JOYFUL VIEW SUBDIVISION

A PART OF THE SOUTHWEST QUARTER OF SECTION 33,
TOWNSHIP 13 SOUTH, RANGE 63 WEST OF THE 6TH P.M.
EL PASO COUNTY, COLORADO

JOYFUL PLAT.DWG
SEPTEMBER 26, 2022
PROJECT 21048
SHEET 1 OF 2

Final plat drawings V1 PCD STAFF CCombined.pdf Markup Summary 11-2-2022

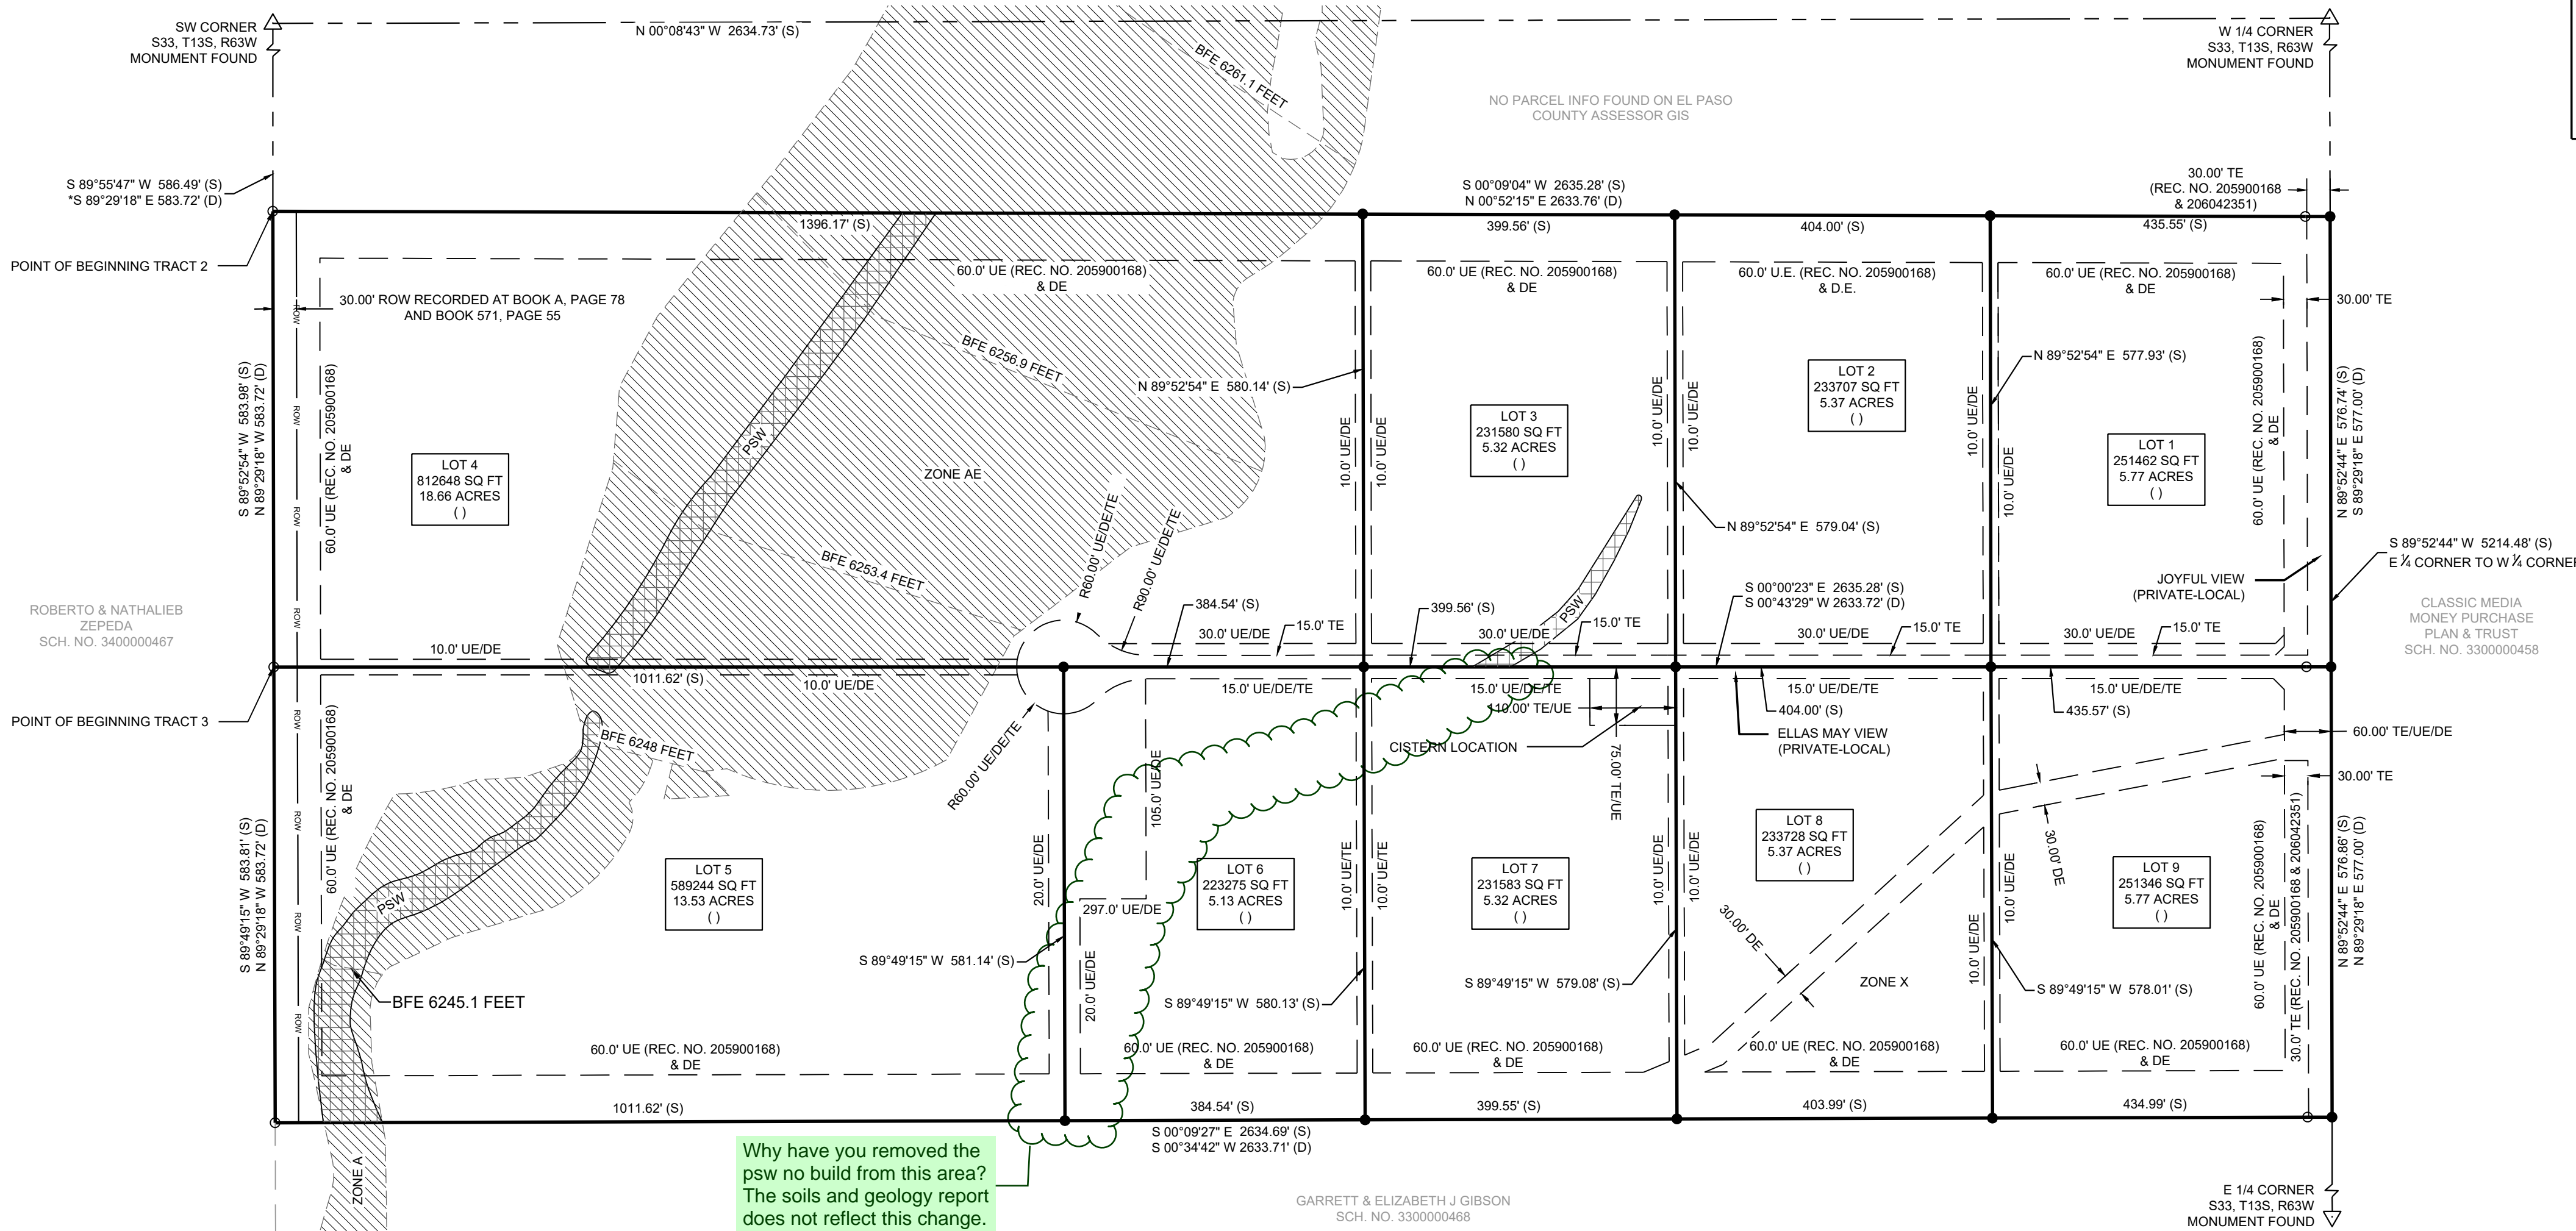
Add required turn around point per FD comments. See note no plat about turn around point beyond floodplain which may not be needed since the road does not continue

Add temp Cul-de-sac and easement per ECM 2.3.8. Address this temp turnaround pt in Plat notes

CD, DR & GEC plans are showing a 30ft utility and drainage easement. Show recorded or planned drainage and utility easements on all effected lots

Both Floodzone X and A are present

Add Base Flood Elevations (BFE)

Please confer with FD about the turn around at this point. They thought the road continued when just the easements are shown. A cul-de-sac is not needed if the road does not continue past the floodplain. Per PHONCON with FD #221025

provide additional easement to accommodate the proposed ditch at the cul-de-sac.

Denote a no build setback line along floodplain boundary

Provide drainage easement for swale/channel at this lot. Coordinate with the drainage engineer.
